Deadline 6: 6th December 2024

Application by RWE Renewables UK Solar and Storage Limited for an Order Granting Development Consent for the Byers Gill Solar Project. PINS Reference No: EN010139.

Bishopton Villages Action Group
Deadline 6 Post-hearing Submissions to ExA
 6th December 2024

**Title**  
**AGRICULTURAL LAND CLASSIFICATION**

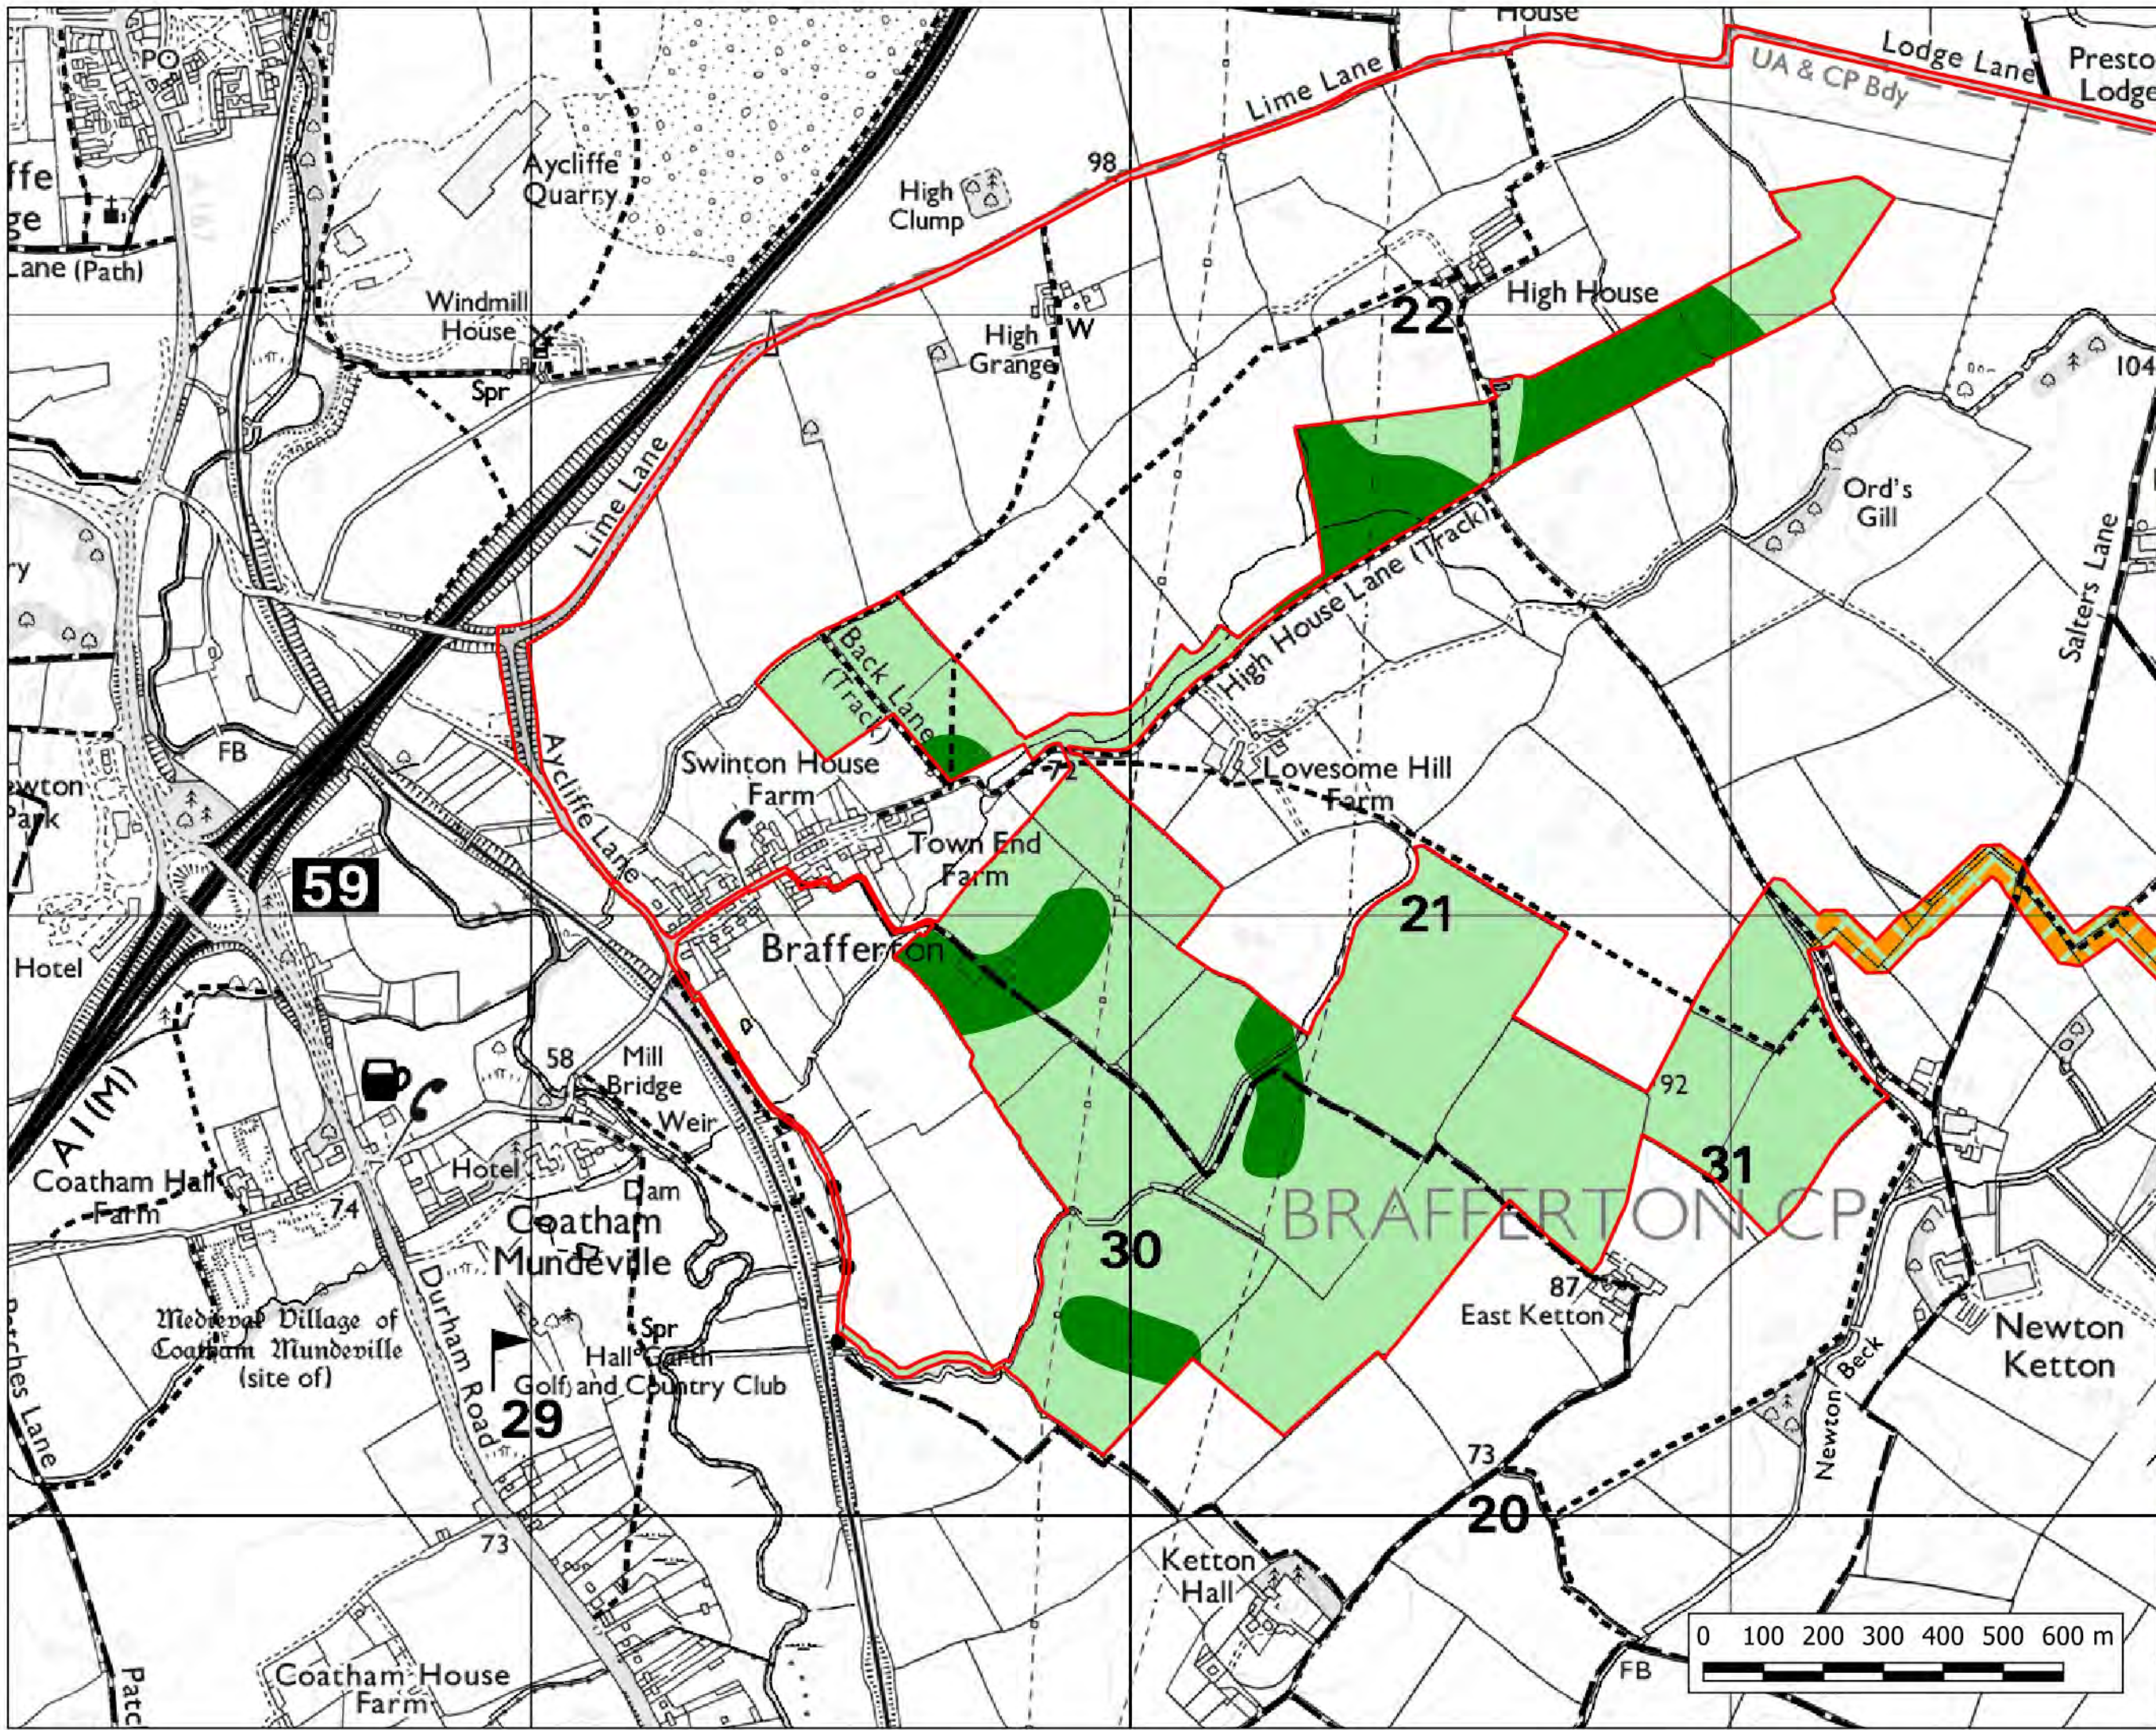
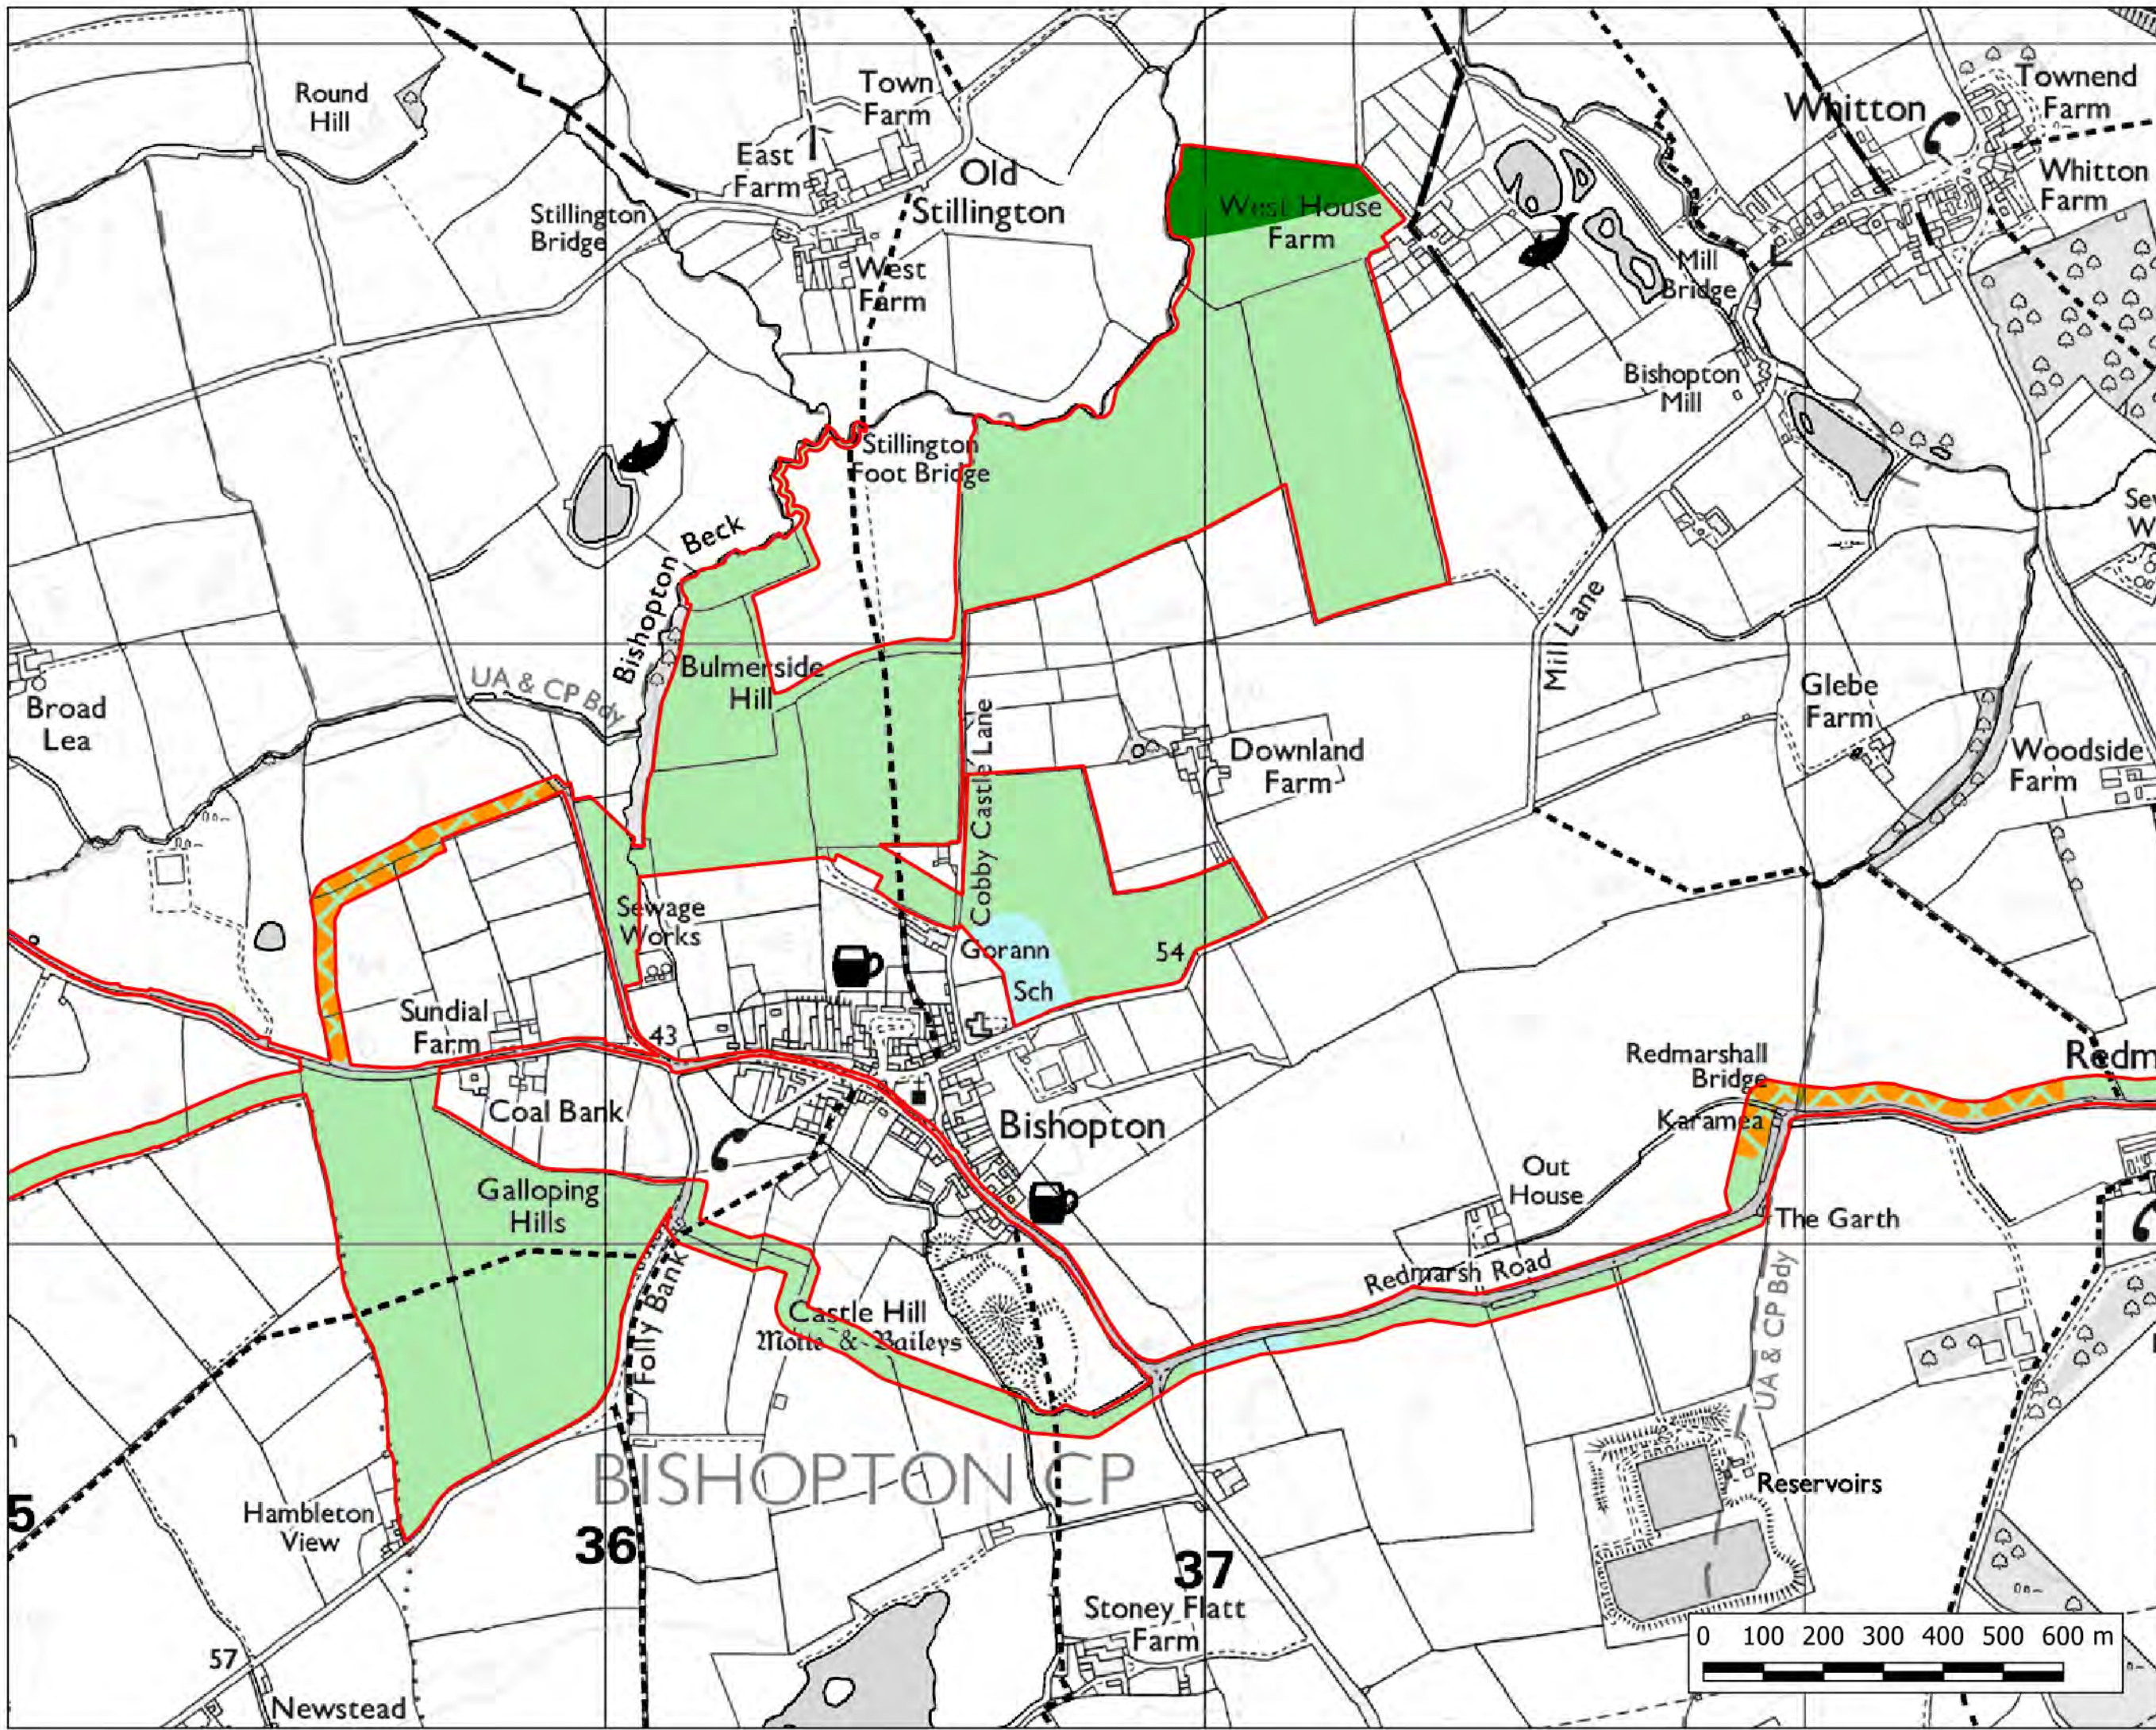
It was further noted by Mr. Anderson during that hearing that the locations of much of the Grade 2 land were located close to villages within the proposal, and that reducing the use of BMV agricultural land had the added benefit of reducing the harm to neighbouring settlements.

In relation to the above comments on overplanting the proposal would benefit from a reduced planting ratio to industry norms, thereby achieving a reduction in the harm to local residents and homes, as well as a reduction in the use of the best agricultural land in compliance with Government policy on renewable energy.

Reference was made to Application Document APP083 (RWE 6.3.9.5 Environmental Statement Figure 9.5 (Agricultural Land Classification)).
